40, Kingsway,
Aldwick,
Bognor Regis,
West Sussex PO21 4DL

Group Head of Planning,
Arun District Council,
Maltravers Road,
Littlehampton. BN17 5LF

AW71/18/HH – 36 Kingsway – Conservation Area – Report - Objection

Drawing
Arboricultural Impact Assessment,
Arboricultural Method Statement

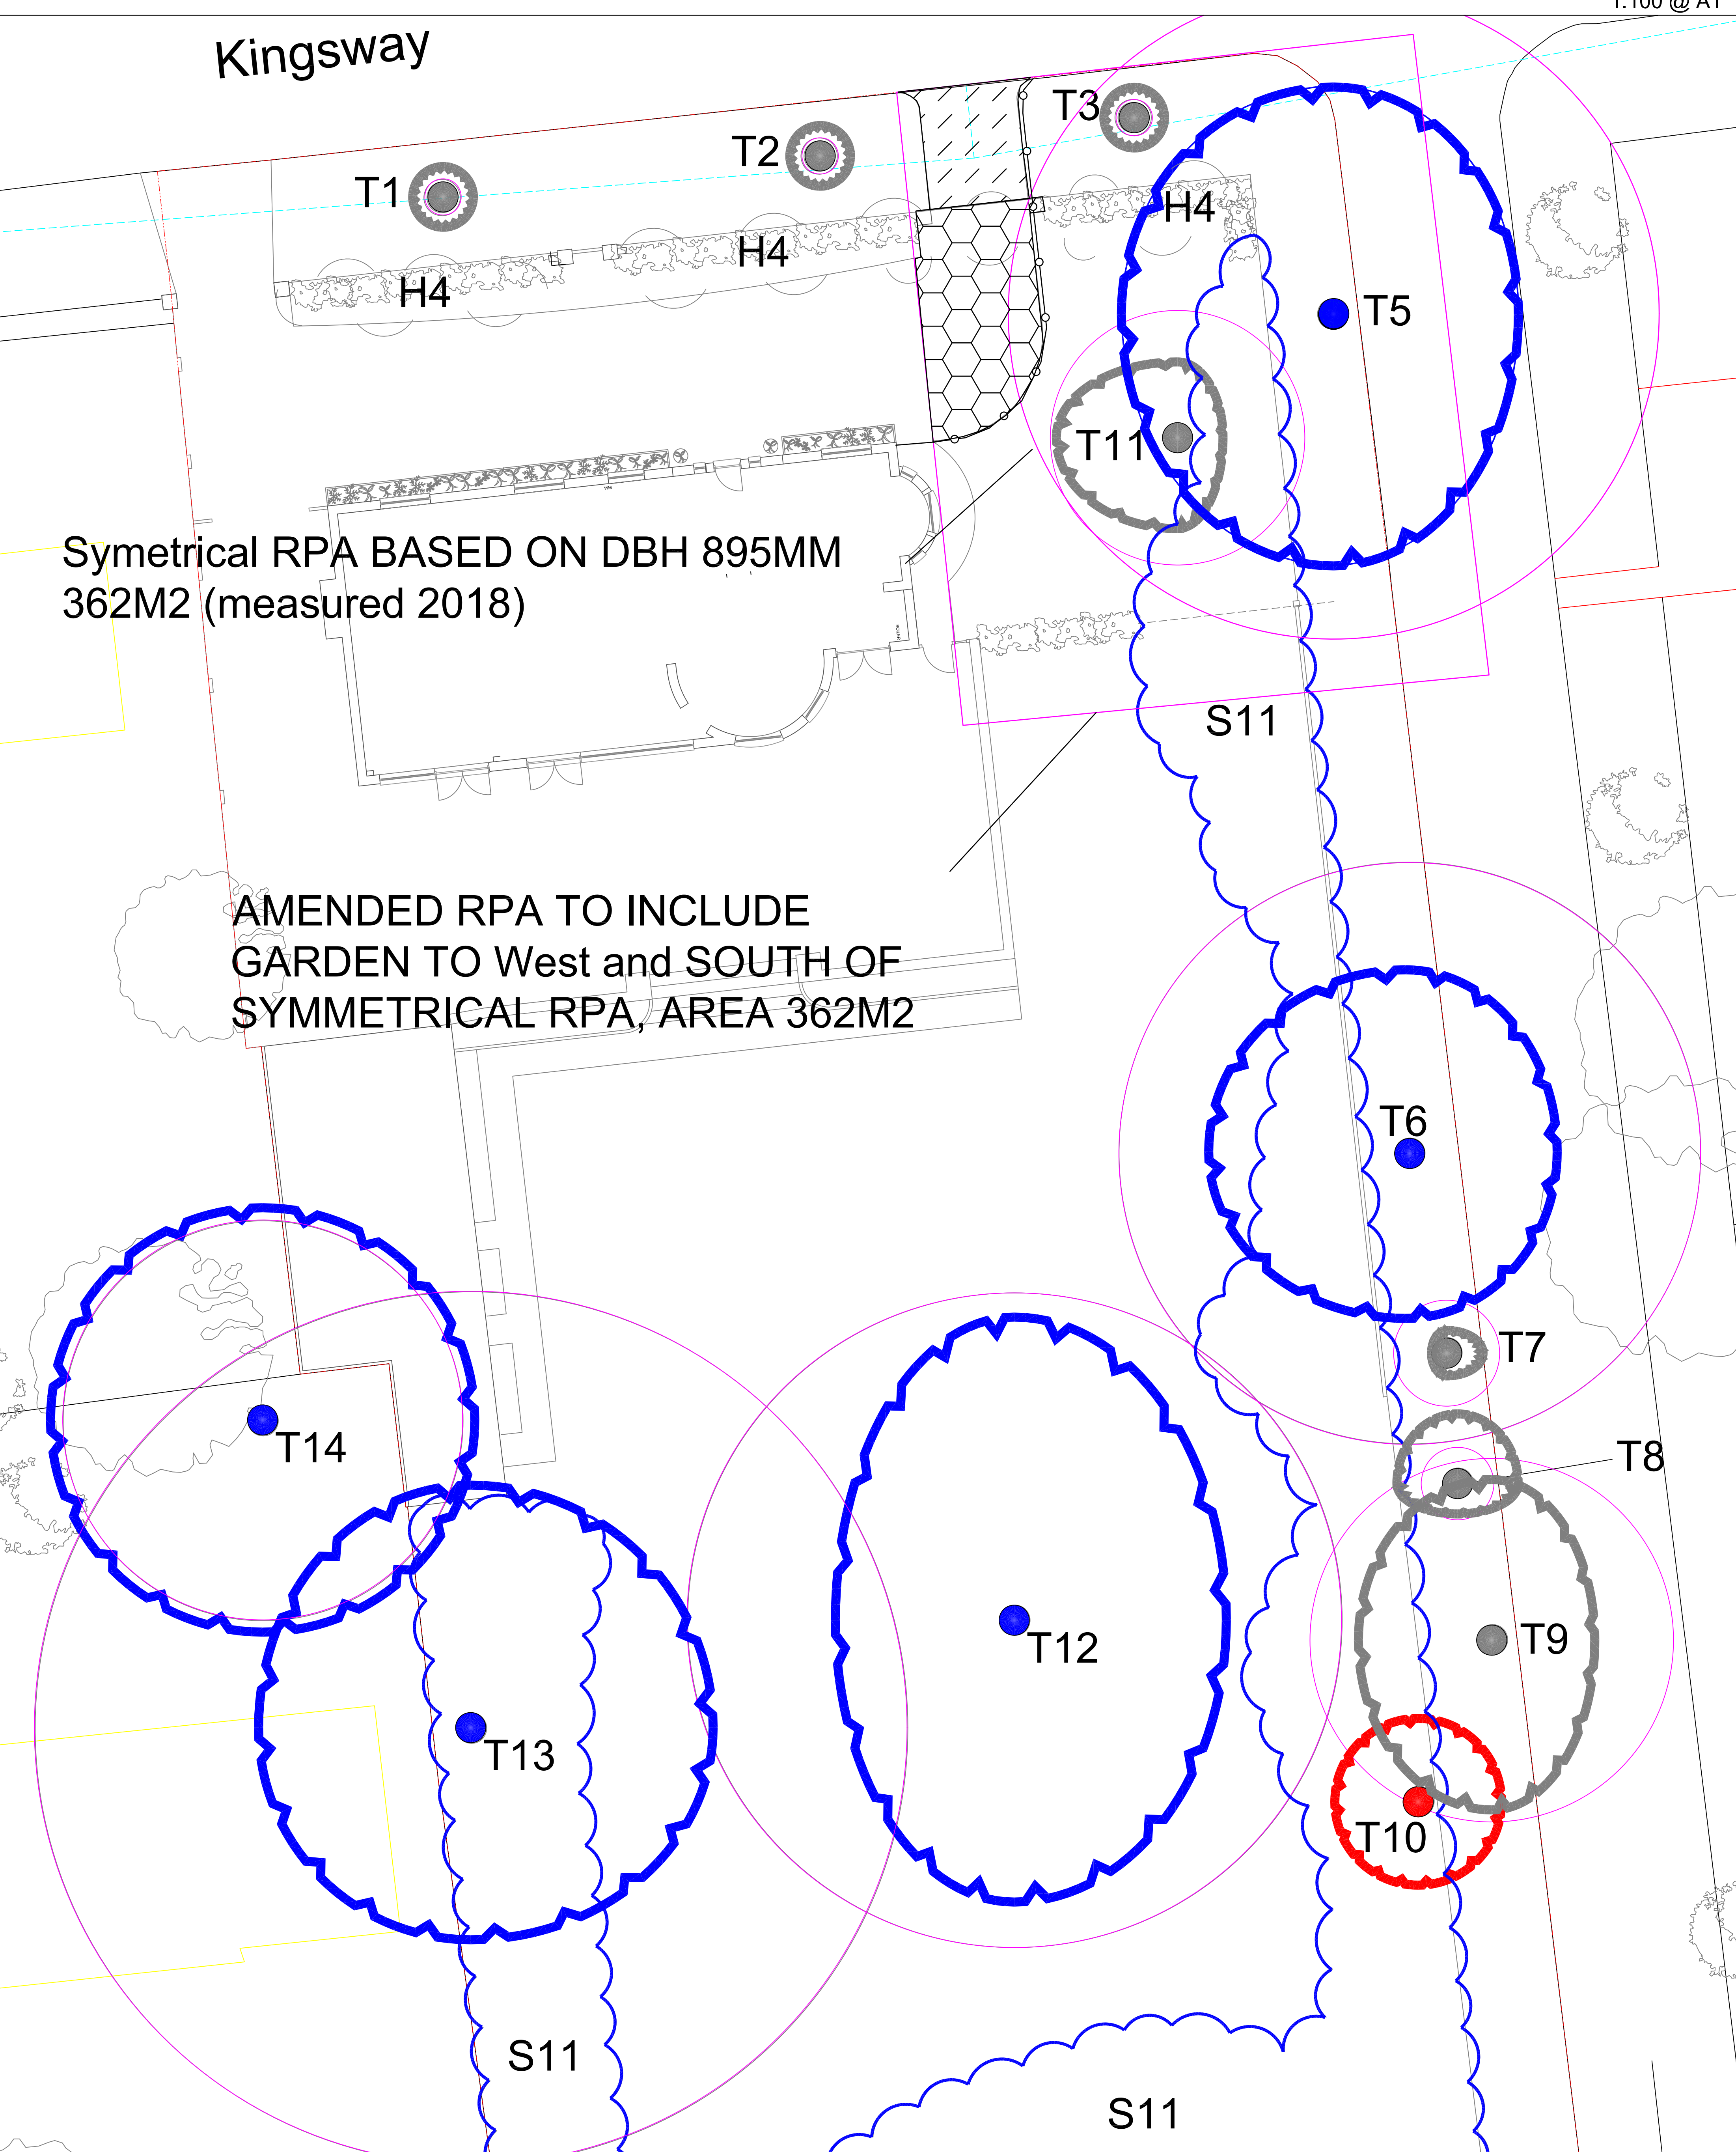
The trees in the hedge H4 are only to be removed, clause 6.3, '*to enable the proposed access from Kingsway*'. This can only refer to the new access and the two or three trees there, as cars can already access the area in front of the house (see aerial photo mentioned above). This arrangement is correctly shown in drawing 602 Rev B. with all but 2 or 3 trees in the hedge retained, but is contradicted elsewhere (Description of

the Application point (2), which also fails to mention closure of the pedestrian access on Kingsway). The latest 3D view 0019SK028B shows the pedestrian gate still in position, but the latest plan drawing AIA/AMS602 Rev.B does not.
